Application No: AL/35/21/DOC
Site Address: Norton Farm House Norton Lane Norton PO20 3NH
Description of works: Approval of details reserved by condition imposed on AL/34/20/PL relating to condition 5-site plan showing details of hard landscaping.

Thank you for your internet representation made on 9th April 2021 which has been recorded as an objection with the comments as follows:

DRAWING TITLE
EXTERNAL WORKS

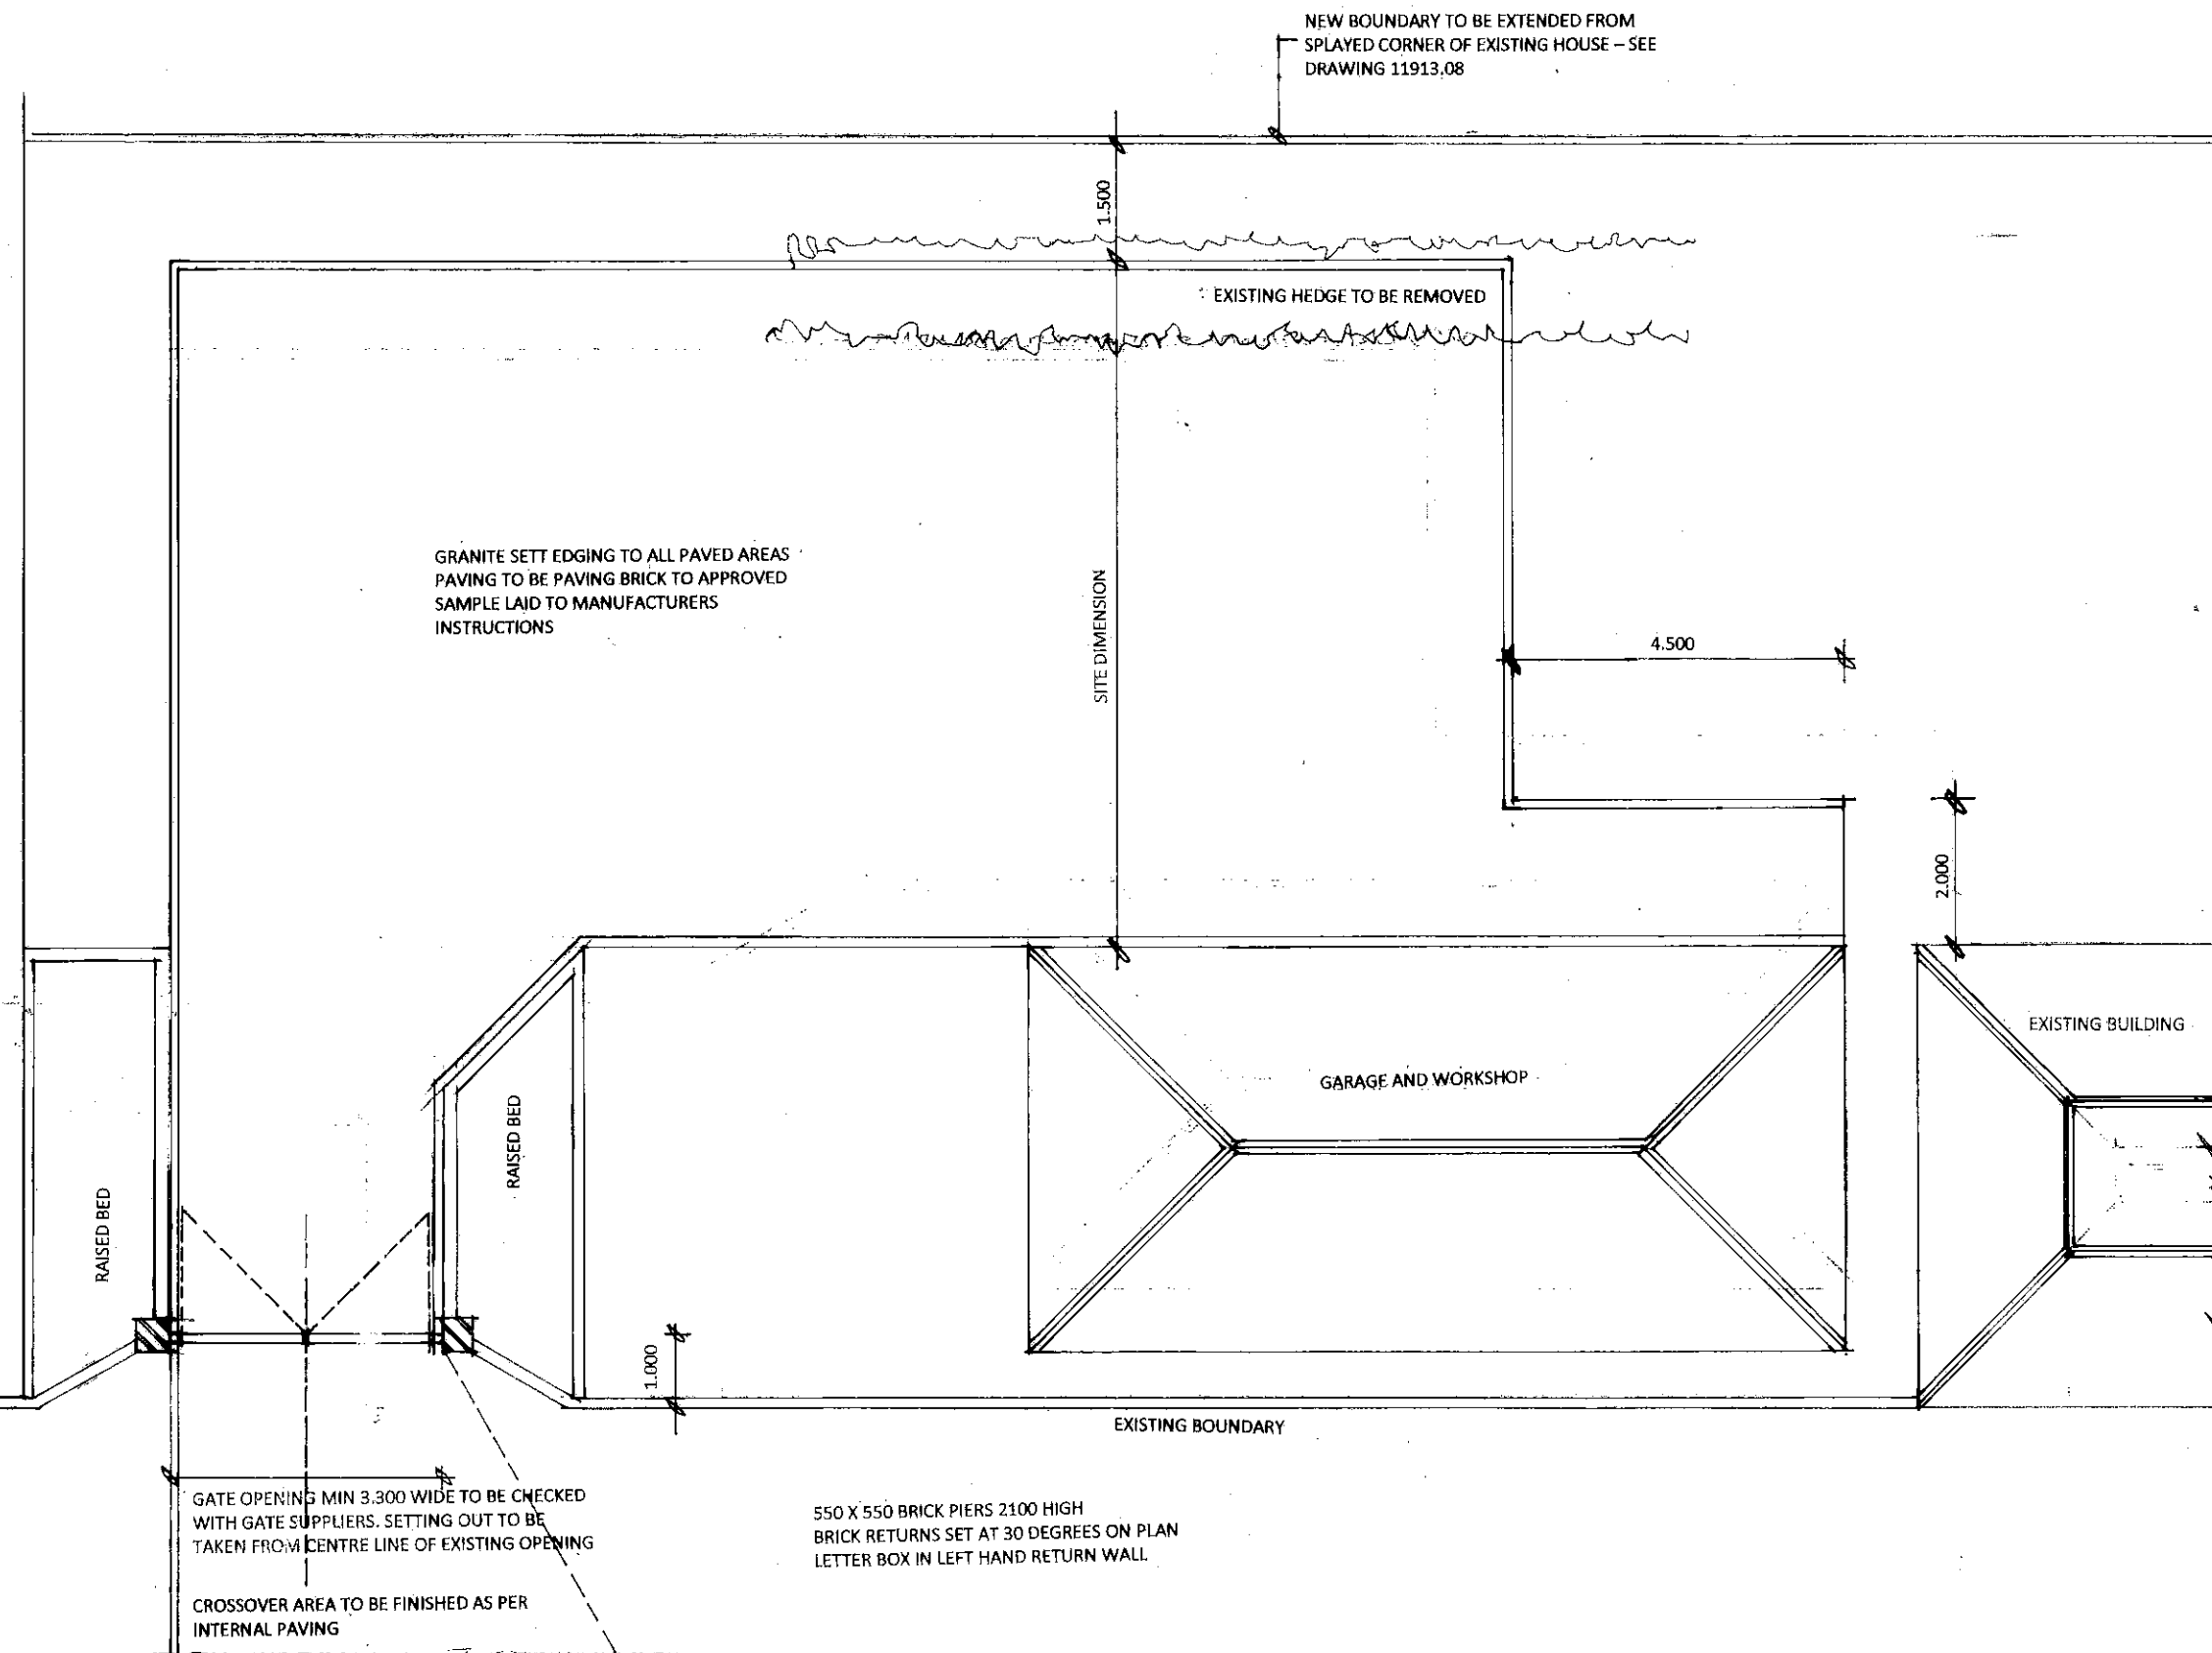
This is the application to fulfill condition 5 regarding the landscaping which this should have been applied for before work taking place. Two large brick piers have been constructed along with paving. The paving is more akin to a modern day housing estate and not in-keeping with a listed building or a Conservation Area, totally out of character. The large new brick piers also look like an entrance to a modern housing estate.

This development is really un-authorised albeit only condition 5 has been applied for 22nd March 2021 only after the brick piers constructed along with most of the paving having been laid beforehand. The plan shows the difference in the roof plan (doesn't depict the difference from the approved oak framed larch weather boarded garage). Surely something more fitting should be approved landscaping wise and not this totally unsuitable plan?

I am hoping that the Council sees sense and approves a landscaping plan suitable for a listed building in a conservation area and not this current plan which is really just a large brick driveway.
